TOWN AND COUNTRY PLANNING ACT 1990 FULL PLANNING PERMISSION

Reference: H23-0201-26
Proposal: Change of use of former telephone exchange to residential dwelling
Location: Former Telephone Exchange Common Road Whaplode Drove Spalding
Applicant: Miss R Baker

Acceptance of Amendment Number 1

Proposed Block Plan
Scale 1:100

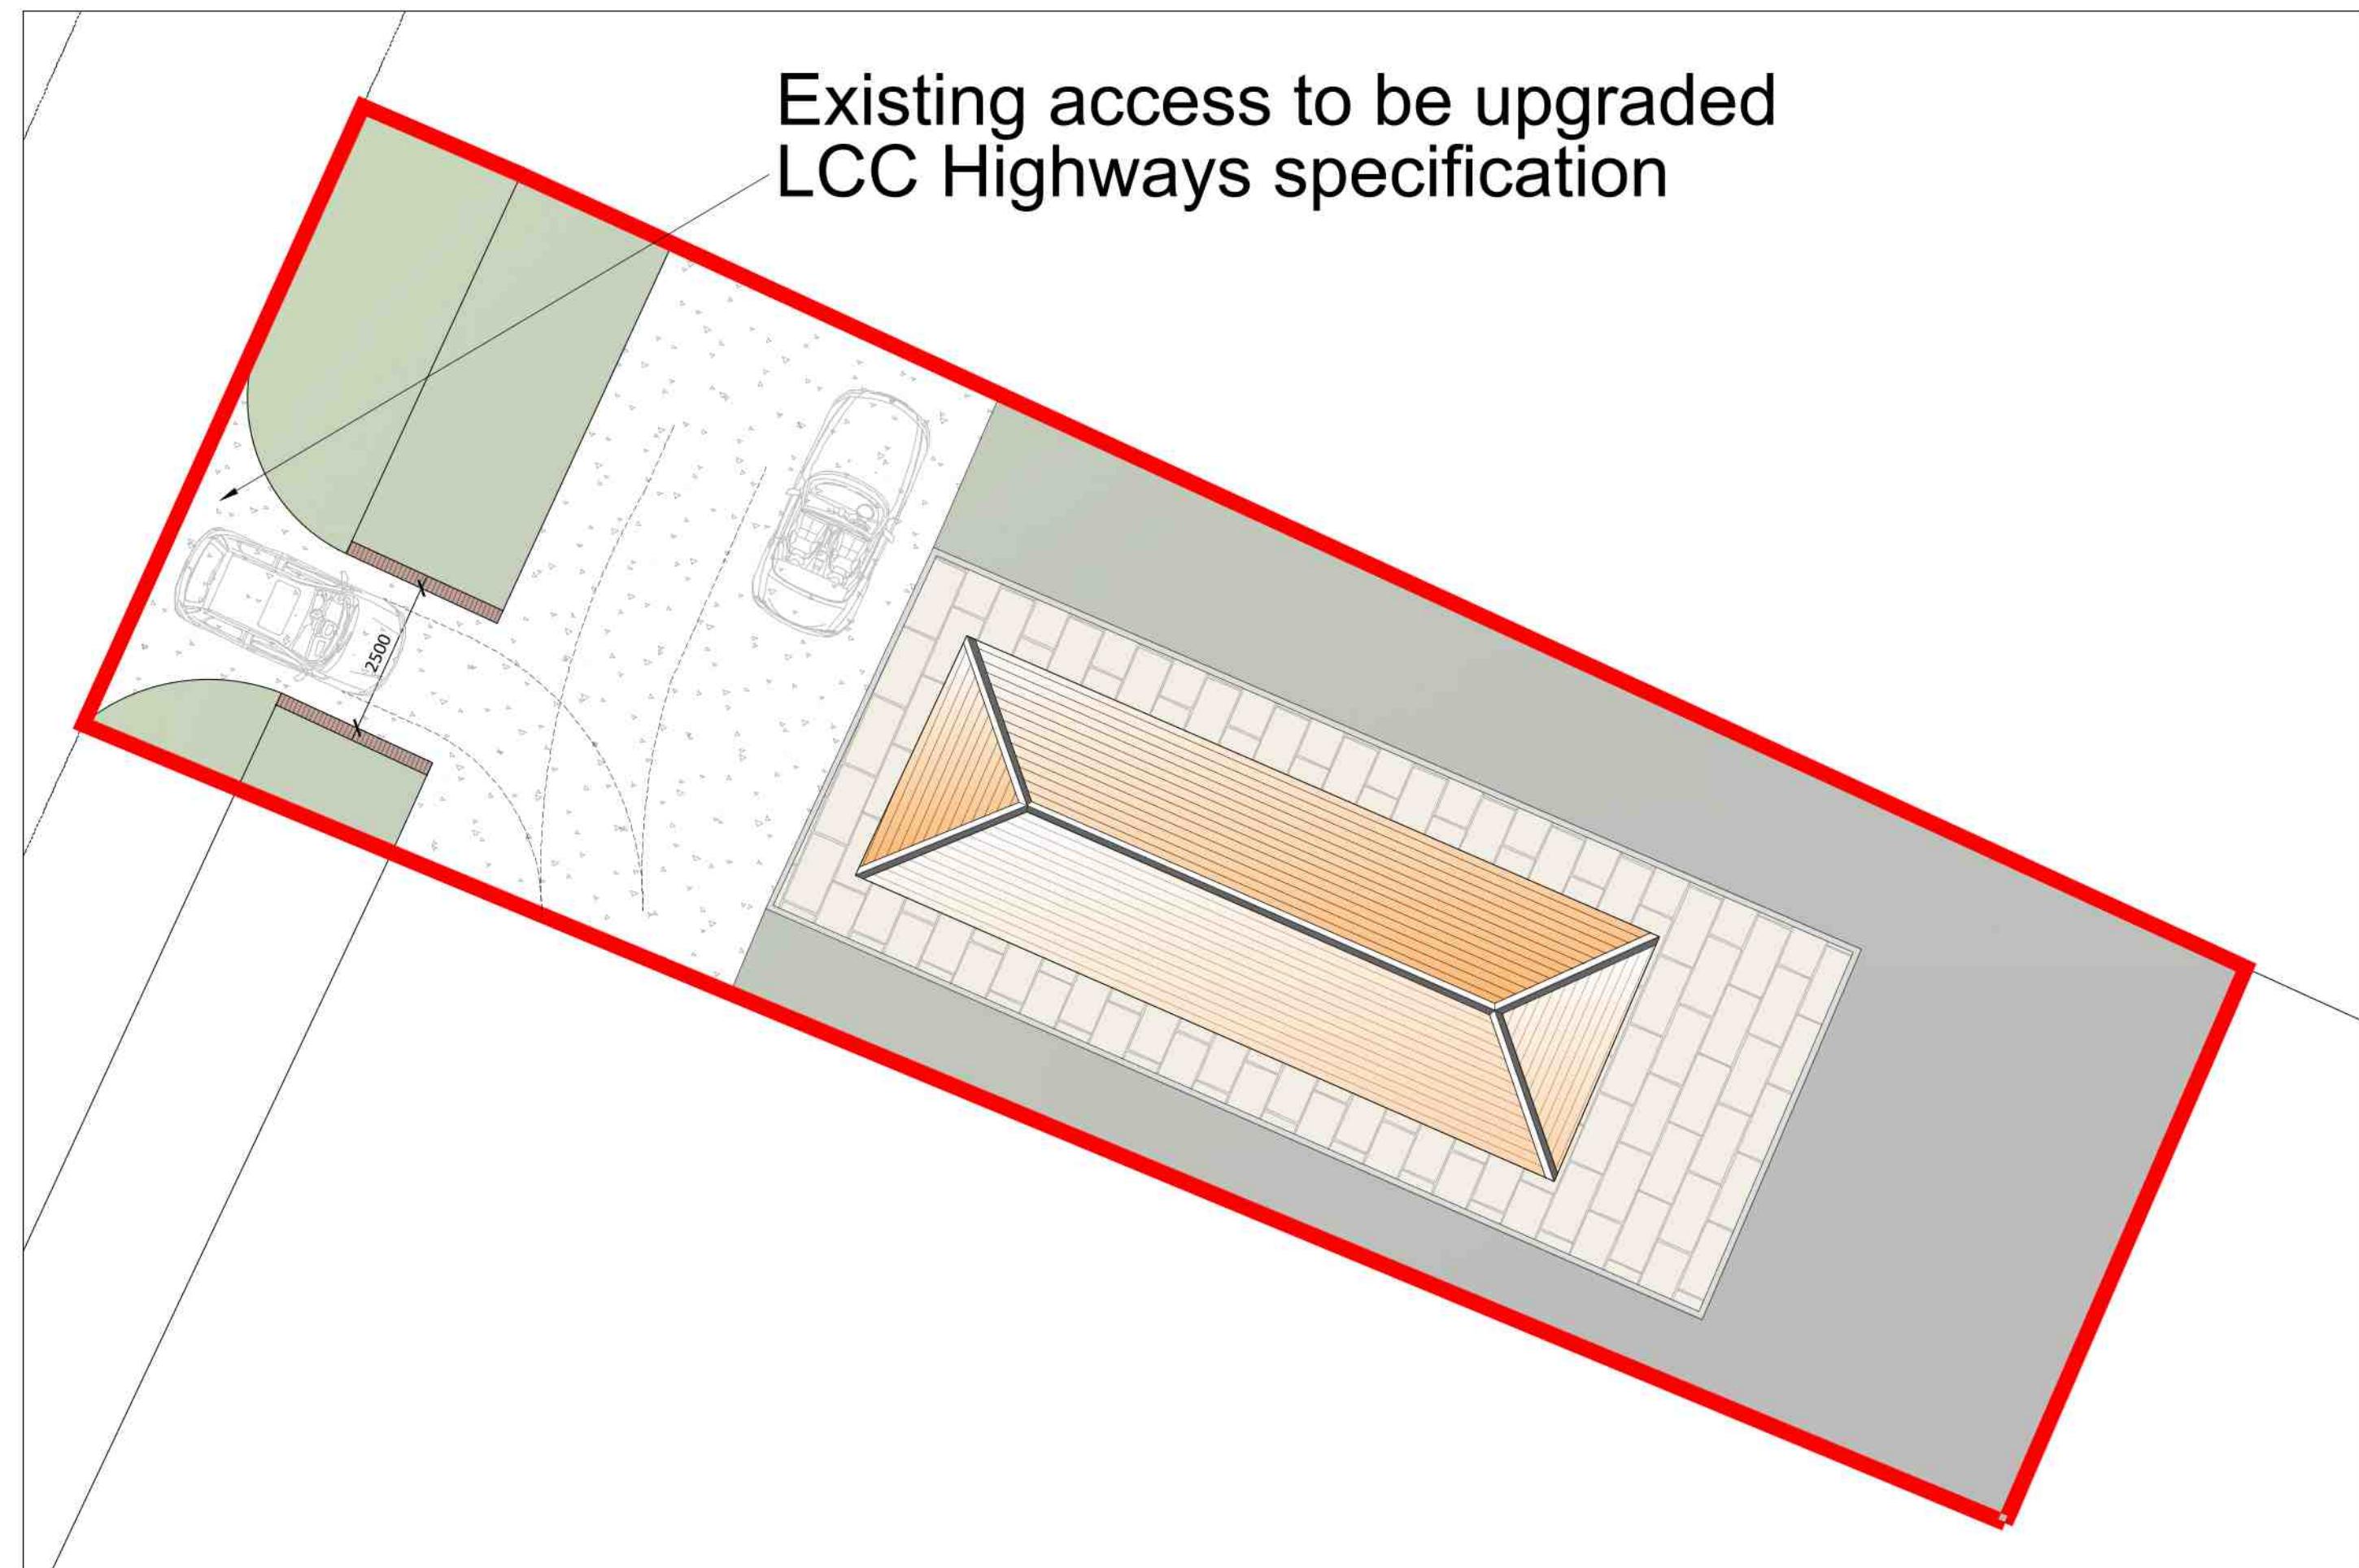
Amended proposed block plan to show removal of garden structure
